**WEST SUSSEX COUNTY COUNCIL
STRATEGIC PLANNING CONSULTATION**

SUBJECT: LU/98/15/PL - Proposed dwelling

25, Peregrine Road, Littlehampton, West Sussex, BN17 6DT

Drawing: **PLANS**

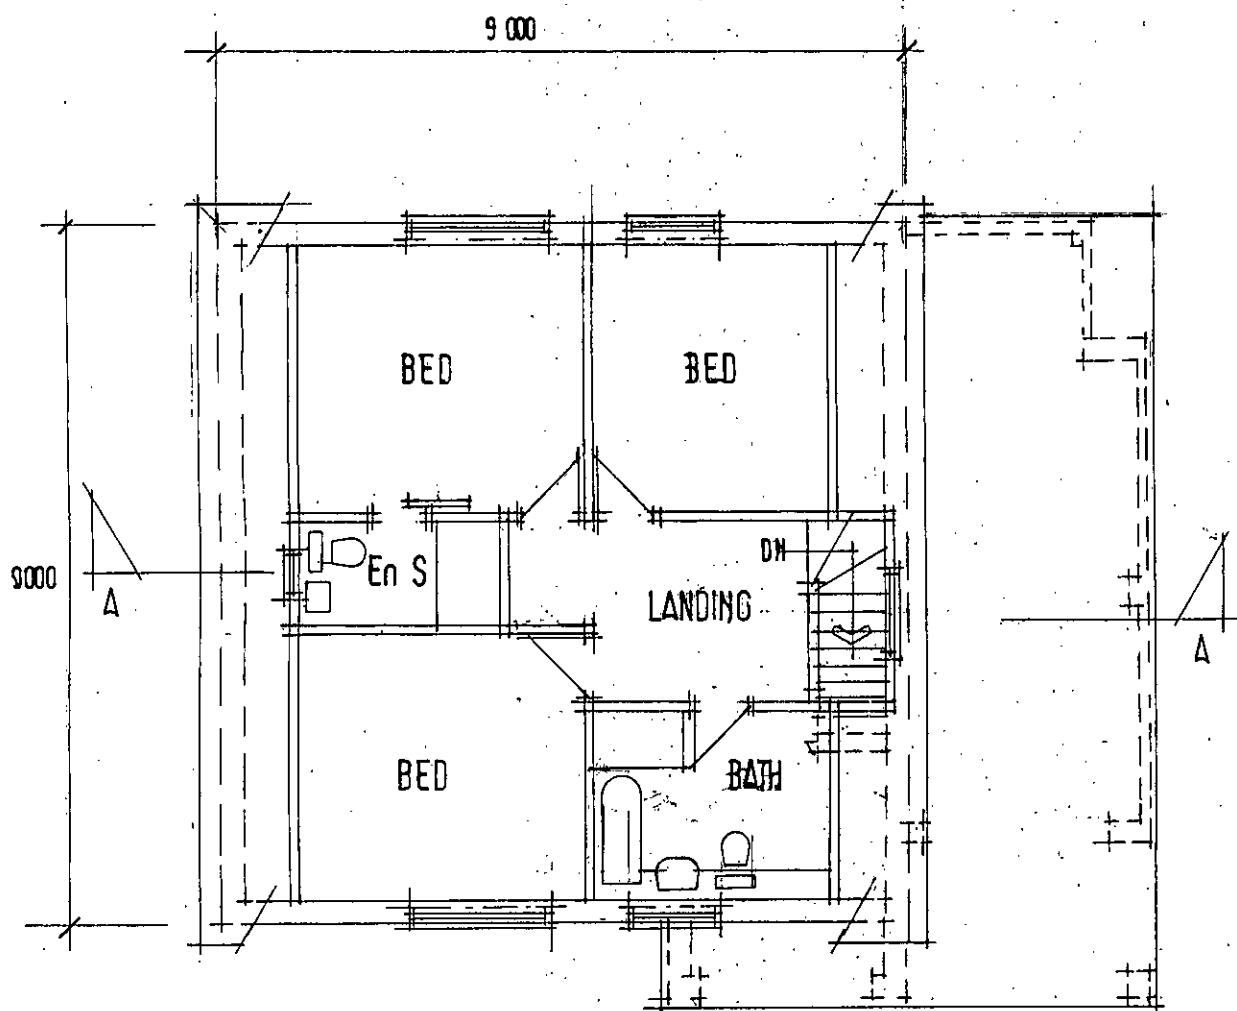
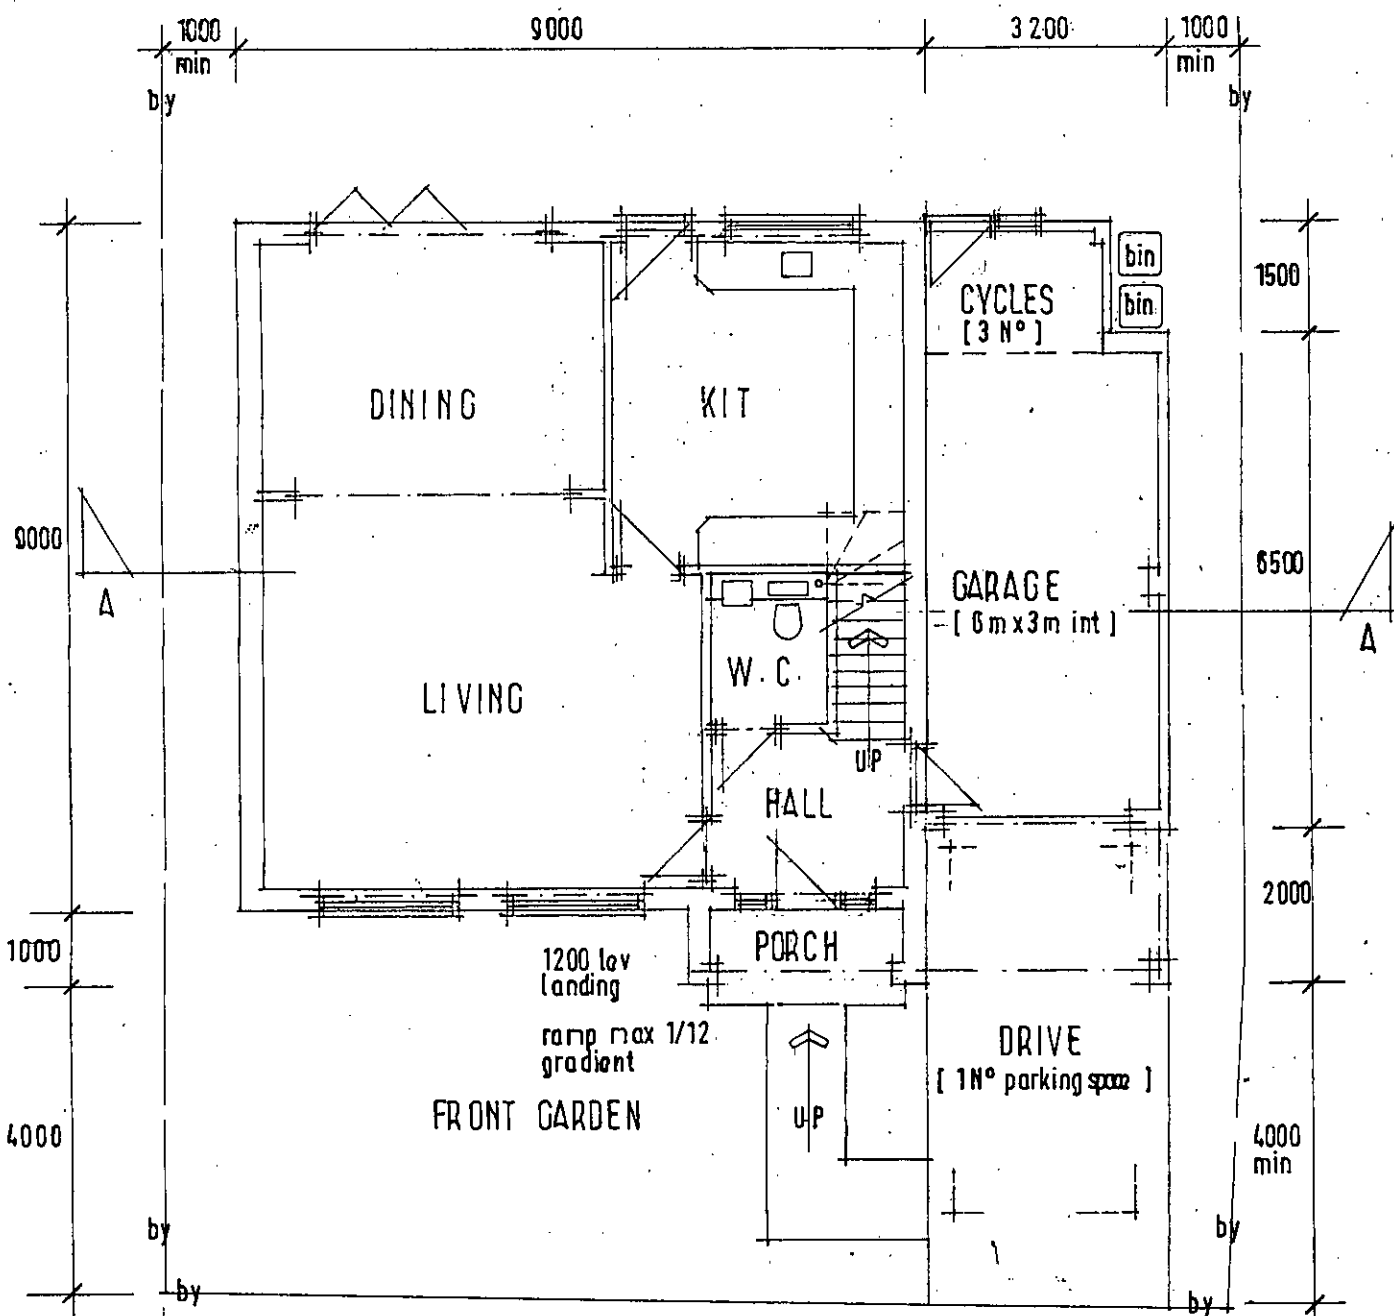
Timberleys is a class "D" residential road with a speed limit of 30mph. The application proposes a new access on to Timberleys, for the proposed new dwelling to the rear of 25 Peregrine Road. The plans indicate an acceptable access width and there would appear to be adequate pedestrian and vehicle visibility in both directions for the new access. It is noted that no turn on site facility is provided, however the precedent of vehicle cross overs and vehicles reversing into the residential road has been set by most of the other local properties in this area. The most recently available accident data indicates there has been no RTA (Road Traffic Collisions) in the vicinity of this proposed access.

In terms of parking the proposed 2 spaces meet with the requirements of the WSCC Parking Demand Calculator (PDC).

The LHA would advise that the access drive be constructed of a bound material, if it is to be constructed from shingle, this may result in material being dispersed onto Timberleys affecting the surface of the road. The applicant should provide a gravel trap or area of block paving, or other bound material, at the point of access onto Crescent Rise on land within the applicant's control.

Cycle parking should be included; this must be secure, covered and be capable of storing at least one cycle per bedroom for each dwelling. The actual details of the cycle parking facilities should be submitted to and approved by the Local Planning Authority (LPA).
